Charlotte Department of Transportation

Memorandum

Date: July 31, 2008

Subject: Rezoning Petition 08-127: Located on the south side of Fairview Road
between Park South Drive and J.A. Jones
Drive

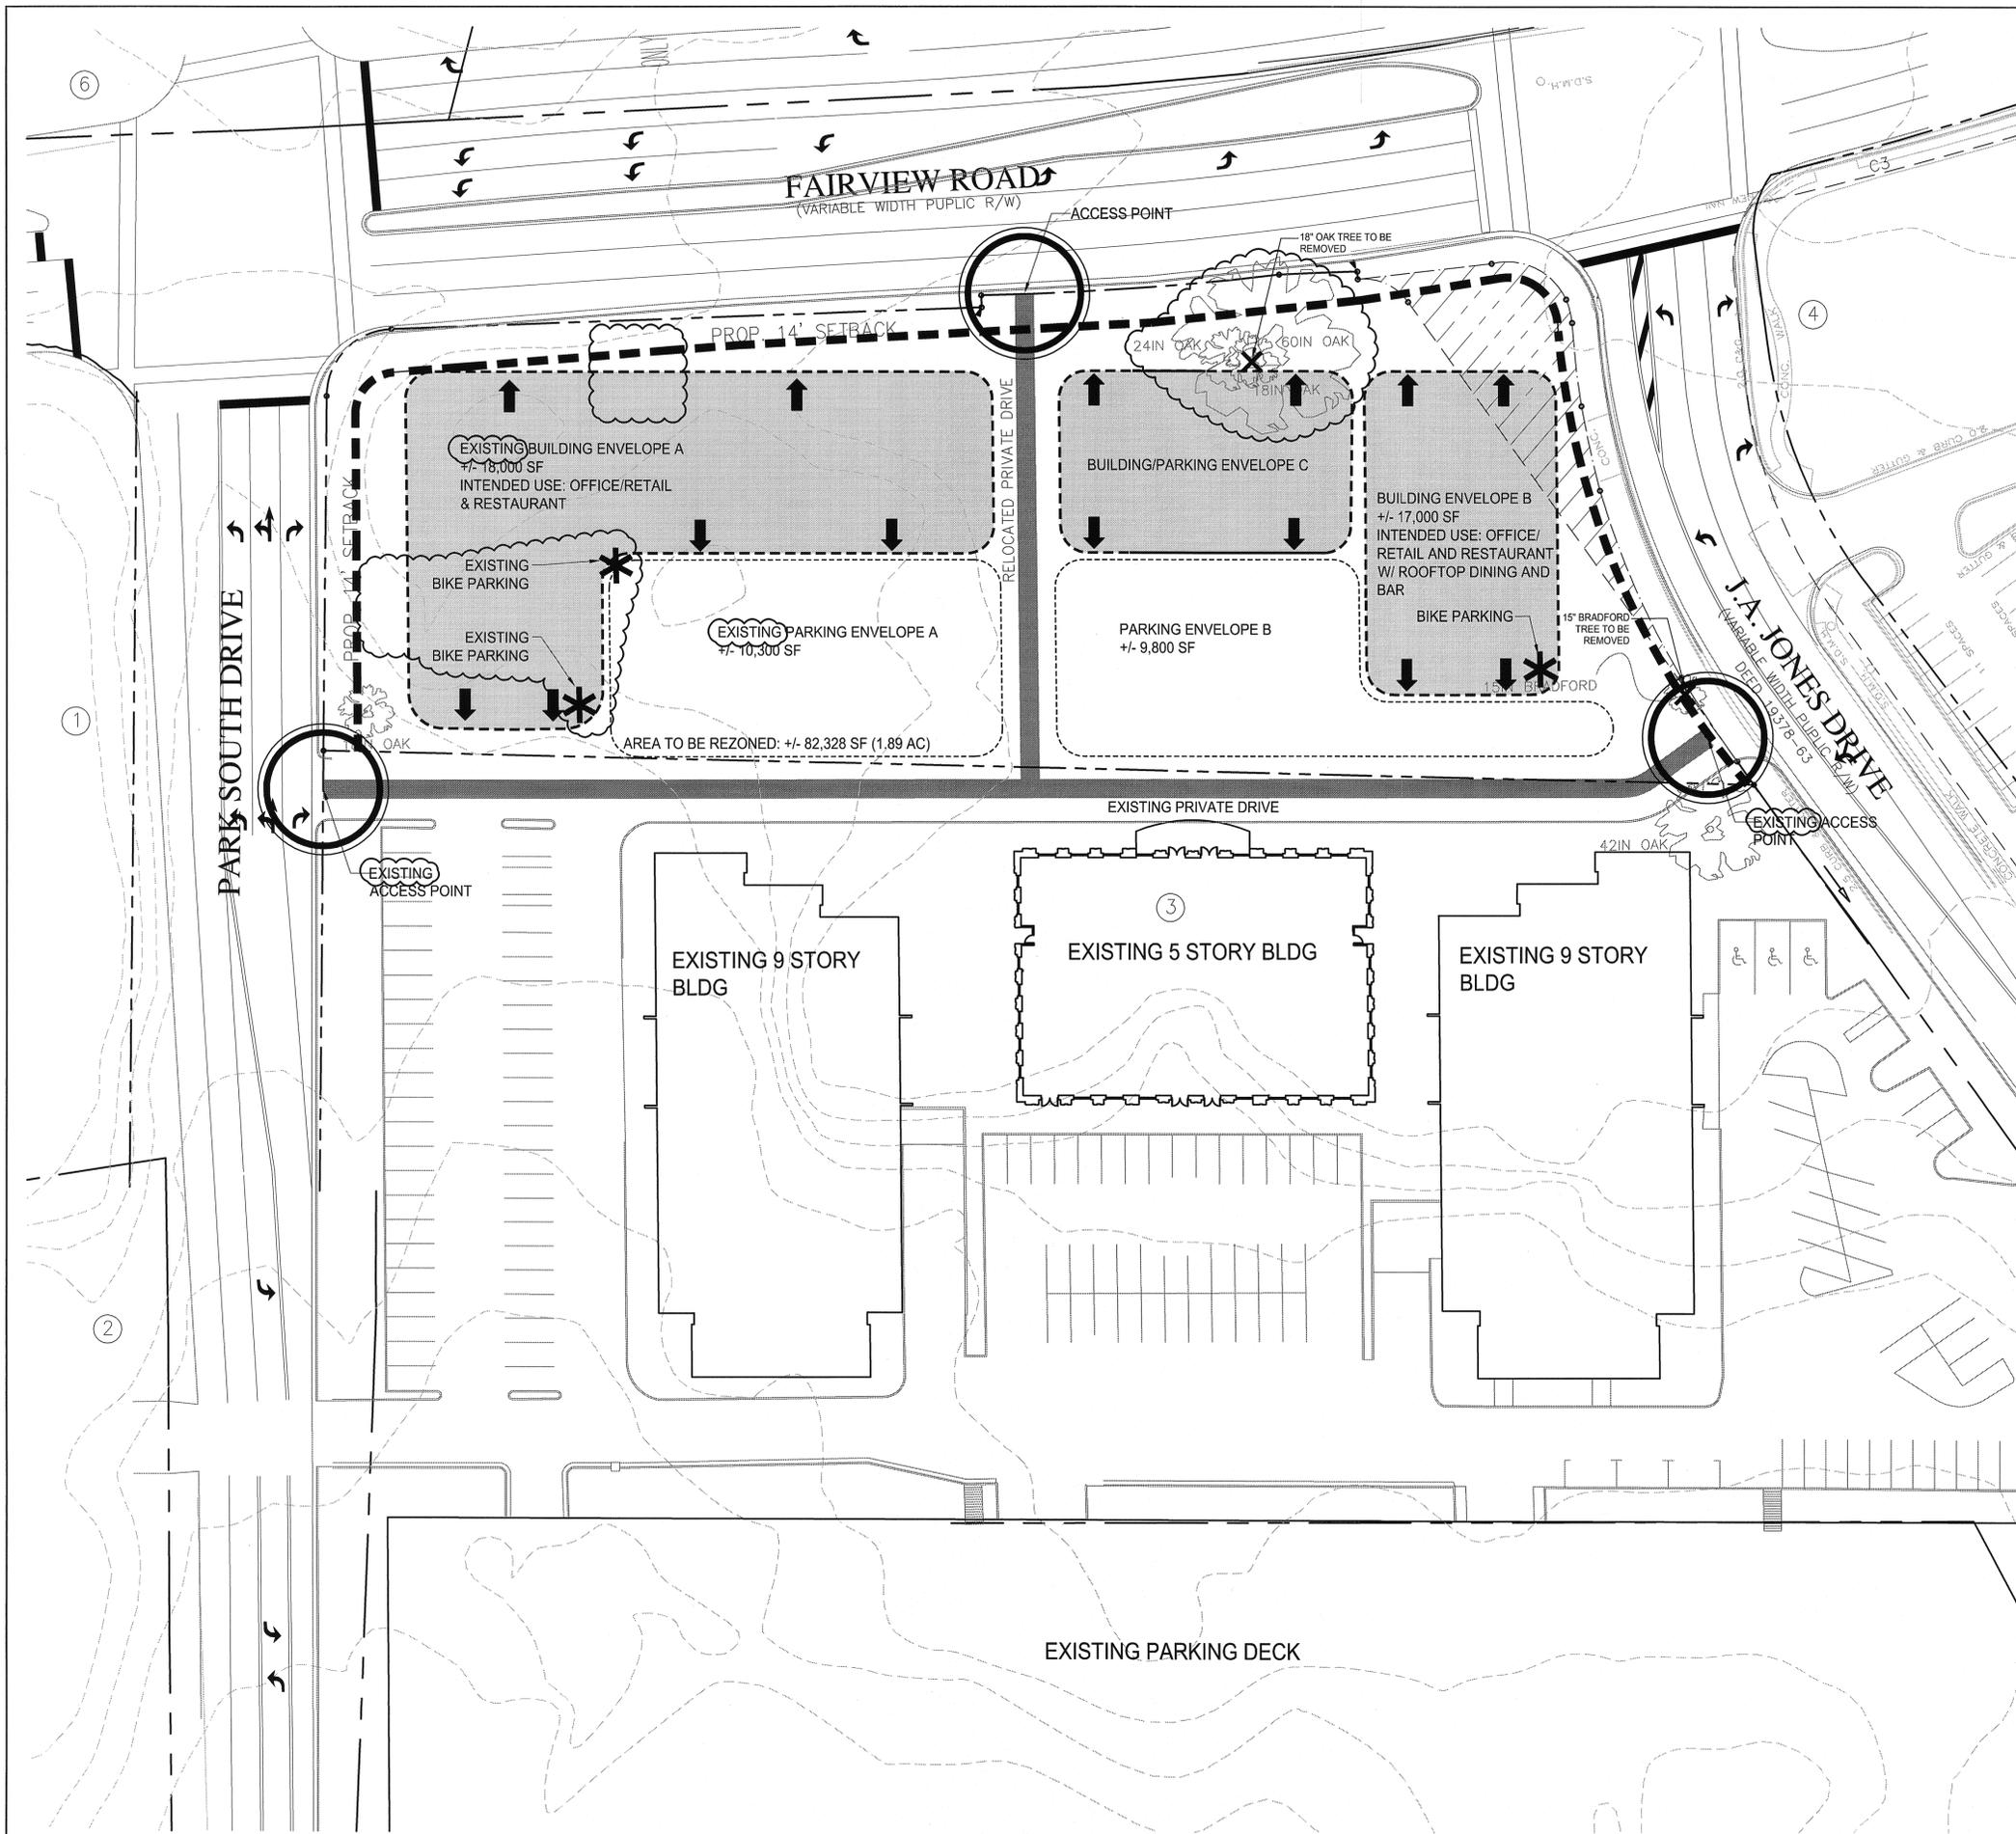
1. The developer needs to replace back-of-curb sidewalks along Fairview Road and J.A. Jones Drive with new 6' sidewalks and 8' planting strips (also required by MUDD zoning).
2. The developer needs to construct 5' sidewalks and 6' planting strips along the relocated private drive running perpendicular to Fairview Road.
3. The developer needs to construct a traffic island along Park South Drive limiting that driveway to right-turn-only access. The driveway onto J.A. Jones Drive is the only driveway that should retain full-movement access.
